## Department of Transportation

Traffic & Safety - Access Permits

RE: PPR2422 - UDON RV Storage Plot Plan Review

The submittals for UDON RV Storage received on September 3, 2024 have been reviewed by CDOT Access Management. Our comments follow:

Conceptual Site Plan

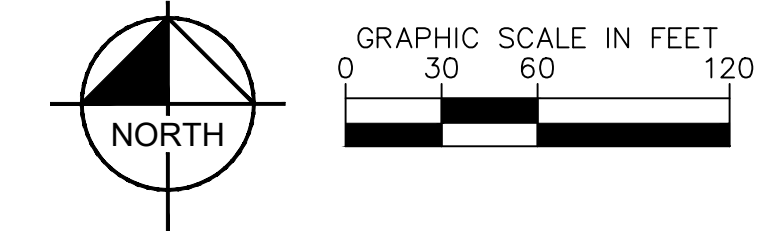
- The access will initially be a T-intersection with only the south area developing in Phase 1.
- Three CDOT Access Permit Applications have been received and are being processed.
